OXFORDSHIRE COUNTY COUNCIL'S RESPONSE TO CONSULTATION ON THE FOLLOWING DEVELOPMENT PROPOSAL

Application No: 19/02550/F

Proposal: Redevelopment of part of golf course to provide new leisure resort (sui generis) incorporating waterpark, family entertainment centre, hotel, conferencing facilities and restaurants with associated access, parking and landscaping

Location: Land to the east of M40 and south of A4095, Chesterton, Bicester, Oxon

Title:  
Proposed Access Arrangement

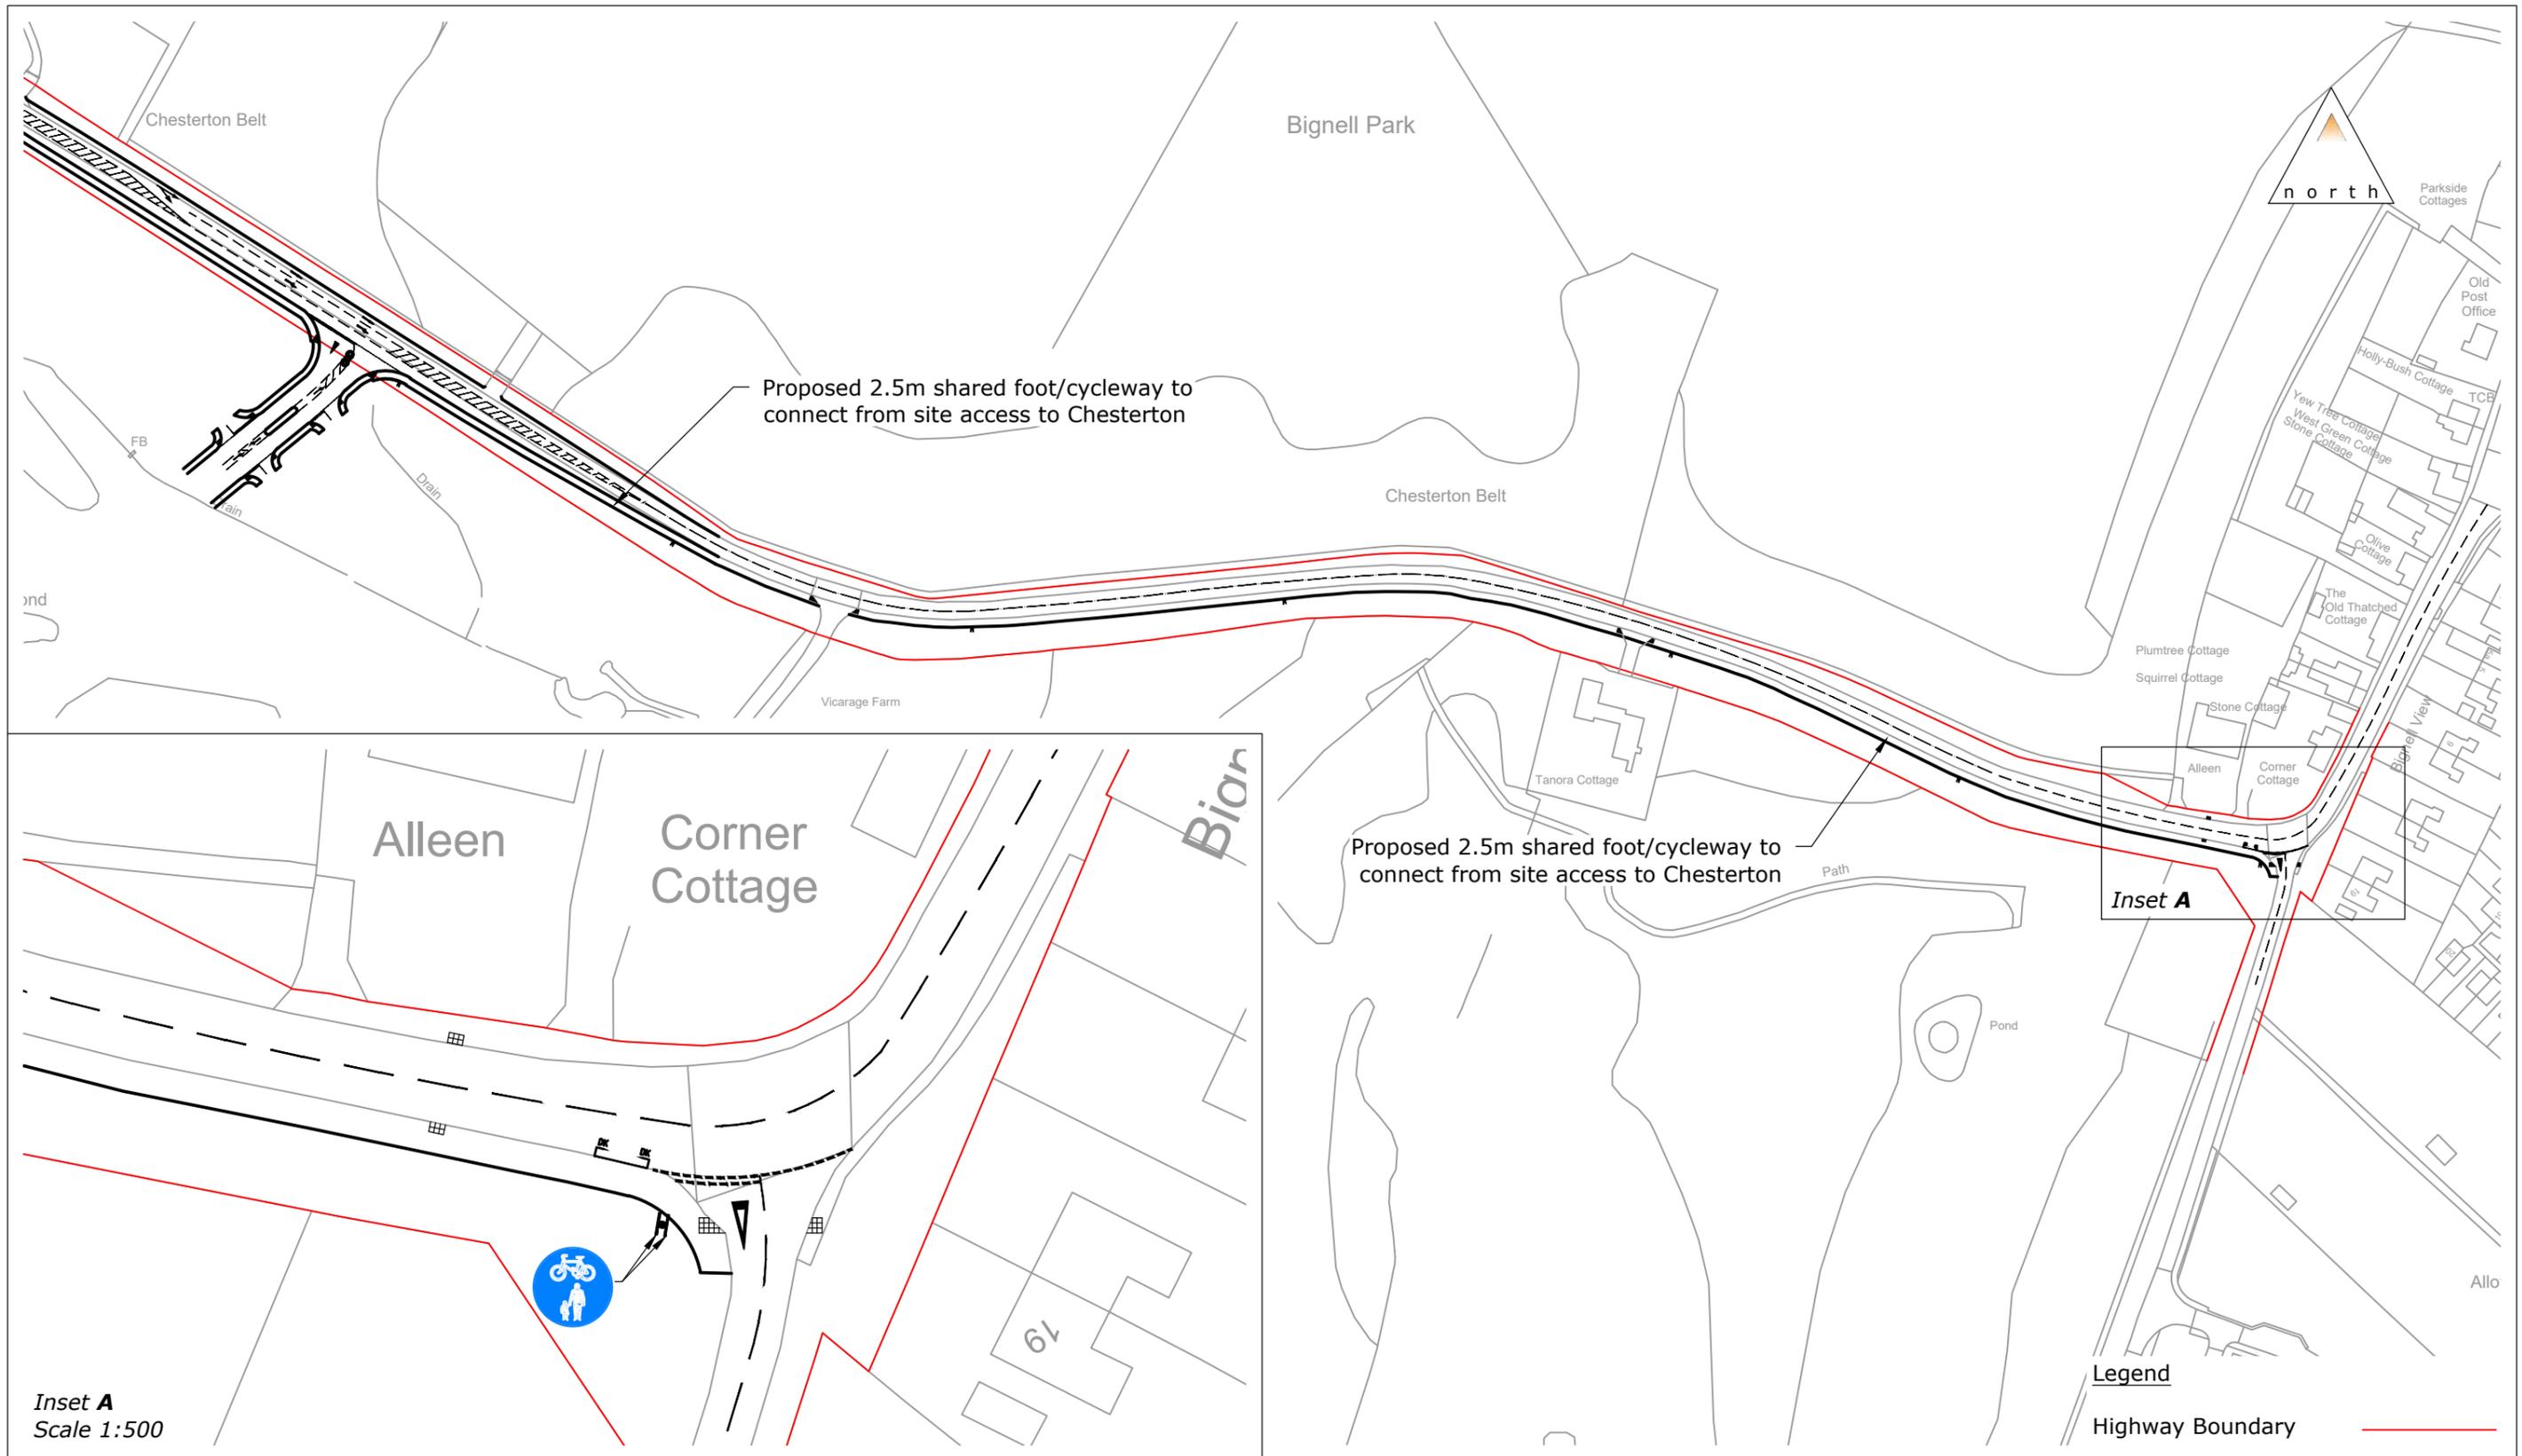
Access to the development site will be via a new priority junction. Speed surveys have been carried out (not included with the submission but viewed by OCC) which indicate that the available visibility splays are adequate according to the requirements of the Design Manual for Roads and Bridges.

The junction design will incorporate a ghosted right-turn lane allowing vehicles arriving on the A4095 from the west to be able to pull off the main carriageway so that they do not cause an obstruction to through traffic while waiting to turn into the site. The minor arm will incorporate a central refuge to aid pedestrians and cyclists continuing along the A4095. Highway works required to create the access will be subject to a S278 agreement.

Title:  
Proposed Shared Foot/Cycleway

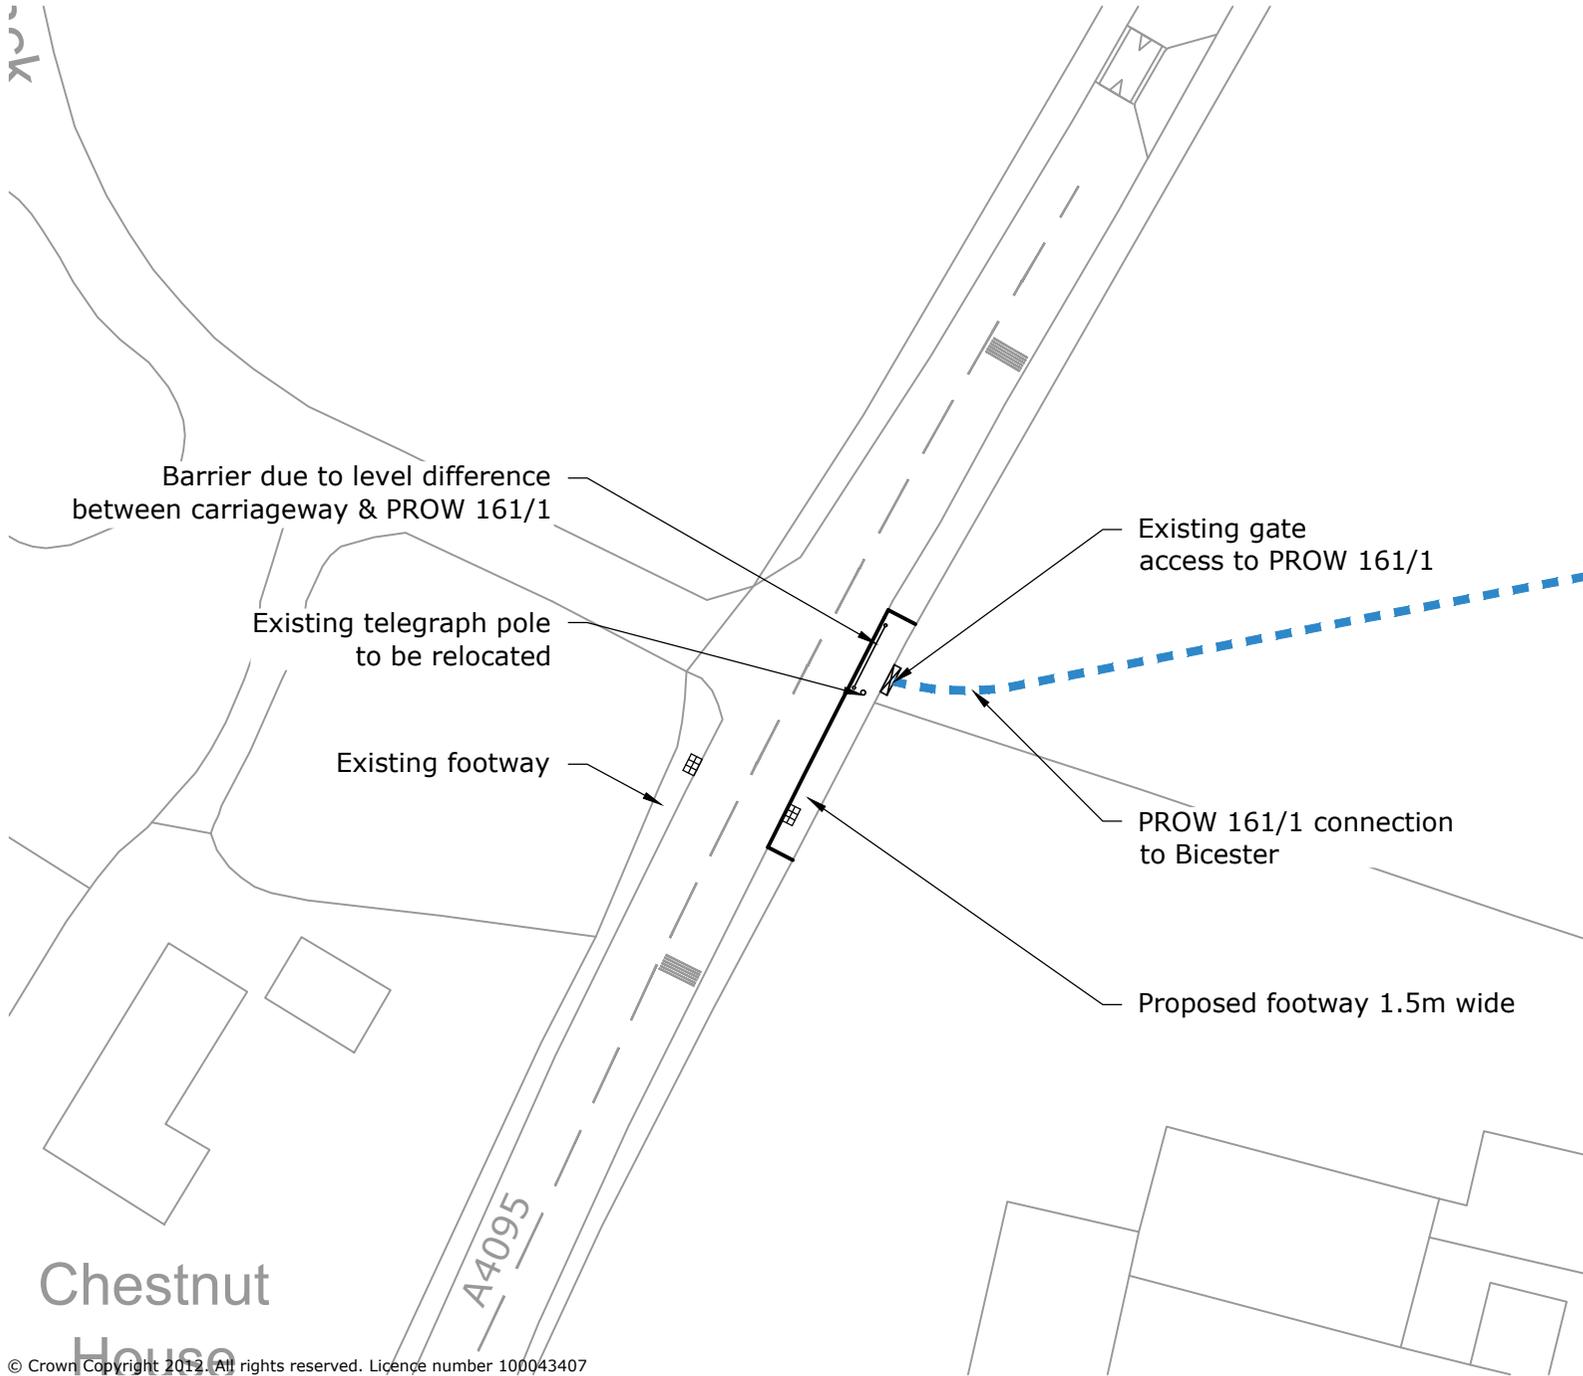
It is noted that a shared use cycle connection is proposed with 2.5m width on the south side of the A4095 between the proposed site access and The Hale. For shared use paths, the Cycling Design Guidance¹ states:

“3.4.9 Usage should dictate the width of such paths, with 3 metres the recommended width, 2.5 metres the minimum. Paths wider than 3 metres should normally be segregated rather than shared.”

Although the pedestrian/cycle measures proposed are welcomed, they are unlikely to make any significant change in modal shift. There is no onward cycle provision on the A4095 through Chesterton and I am not aware of any funding mechanism in place to deliver cycle provision through the Country Park between Chesterton and Bicester.
